Consultee Comments for Planning Application 21/00009/FULL

Address: 25 Anglesey Arms Road Gosport Hampshire PO12 2DG

Proposal: INSTALLATION OF TO NEW UPVC WINDOWS AND RE-PROPORTIONED KITCHEN WINDOW TO FRONT (NORTH) ELEVATION AND REFURBISHED FIRST FLOOR BALCONY WITH GLASS BALUSTRADE (ARTICLE 4(2) AND CONSERVATION AREA)

CONSERVATION OFFICER: Richard Whittington

Job Number & Drawing Number	Revision
20-075-PL202

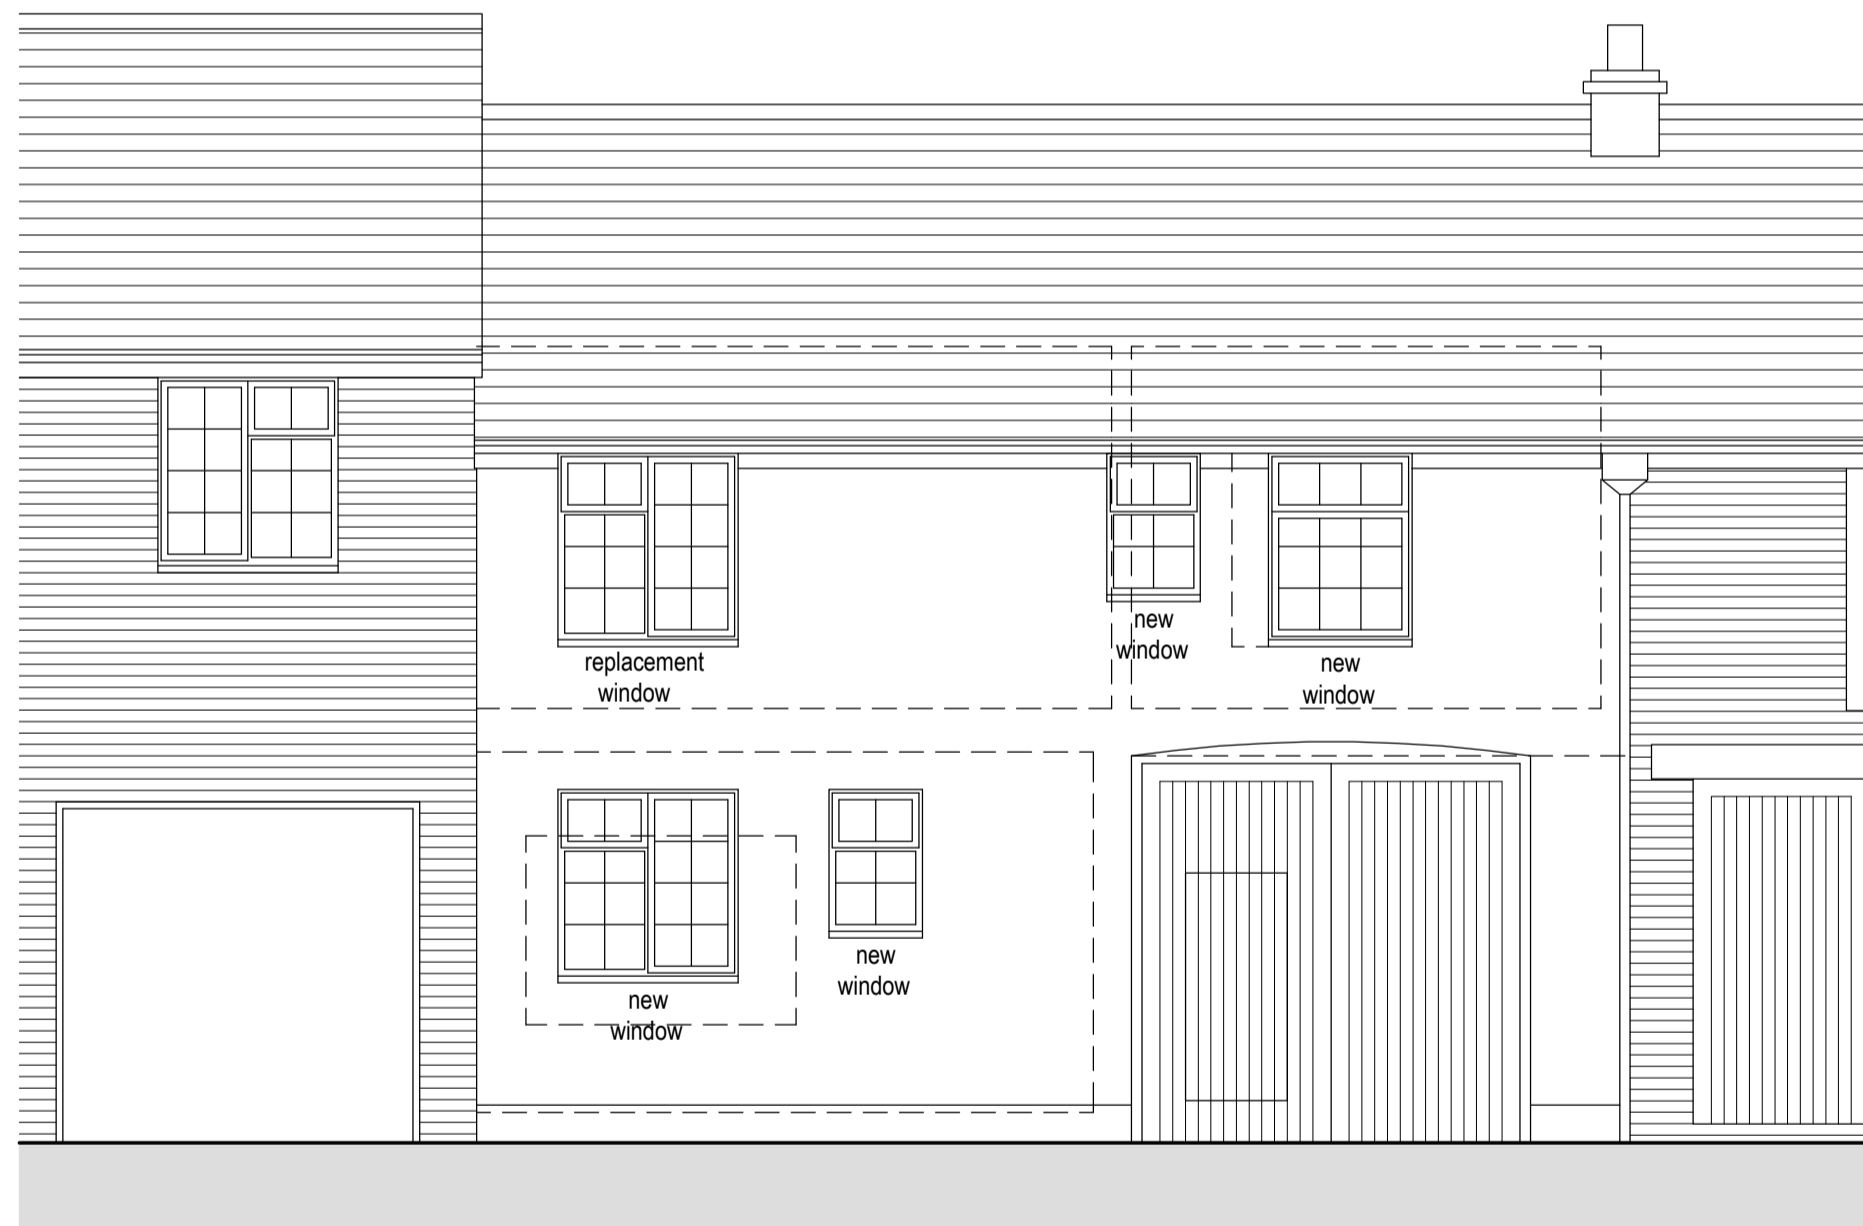
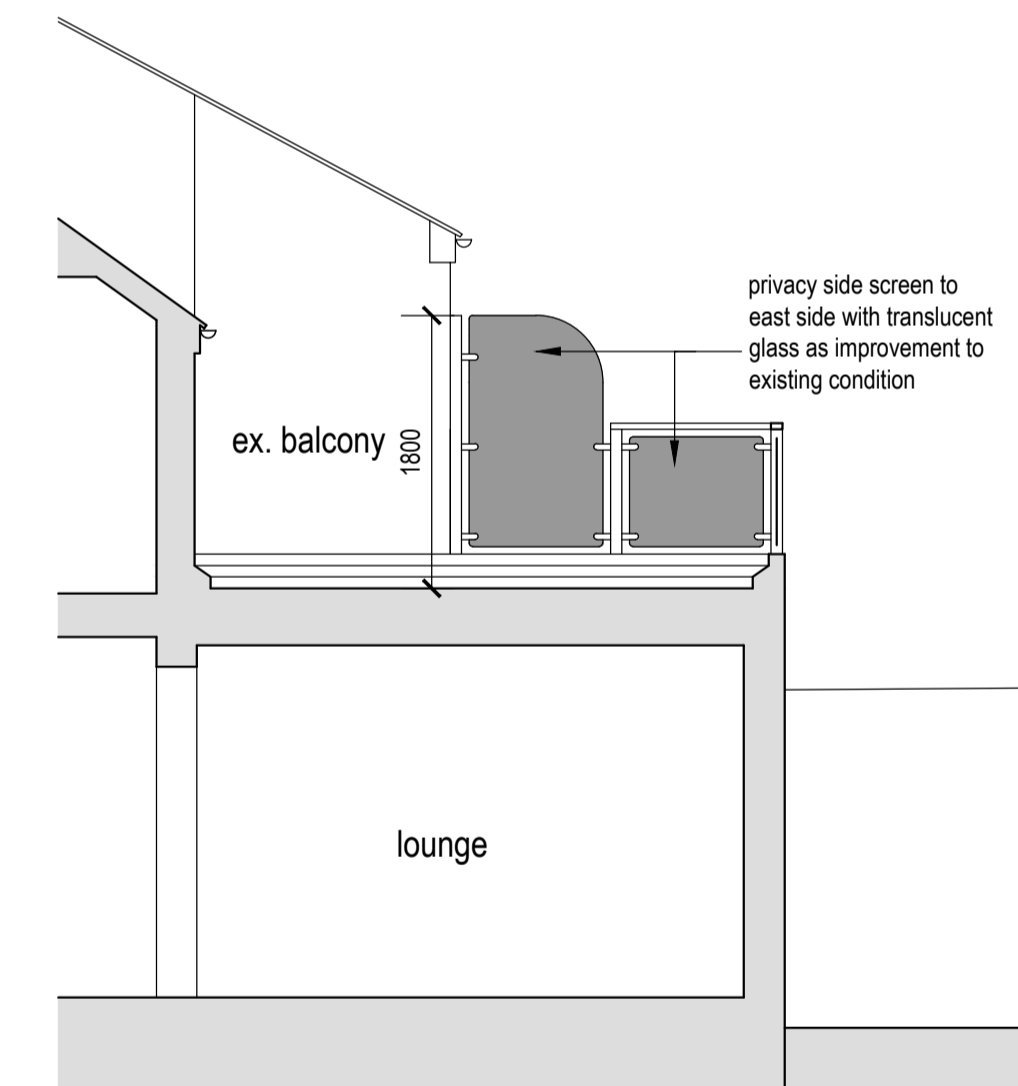
Additionally, the dwelling is sensitive to inappropriate change given the former association of the dwelling with the Grade II* 12 Crescent Road in close proximity. The installation of modern upvc windows in a historic building within the setting of the high status listed building is considered moderately harmful, though at the lower end of the scale of less than substantial harm, as set out in the NPPF.

If the proposed windows were amended to be of slimline timber double glazed construction the application would be acceptable.
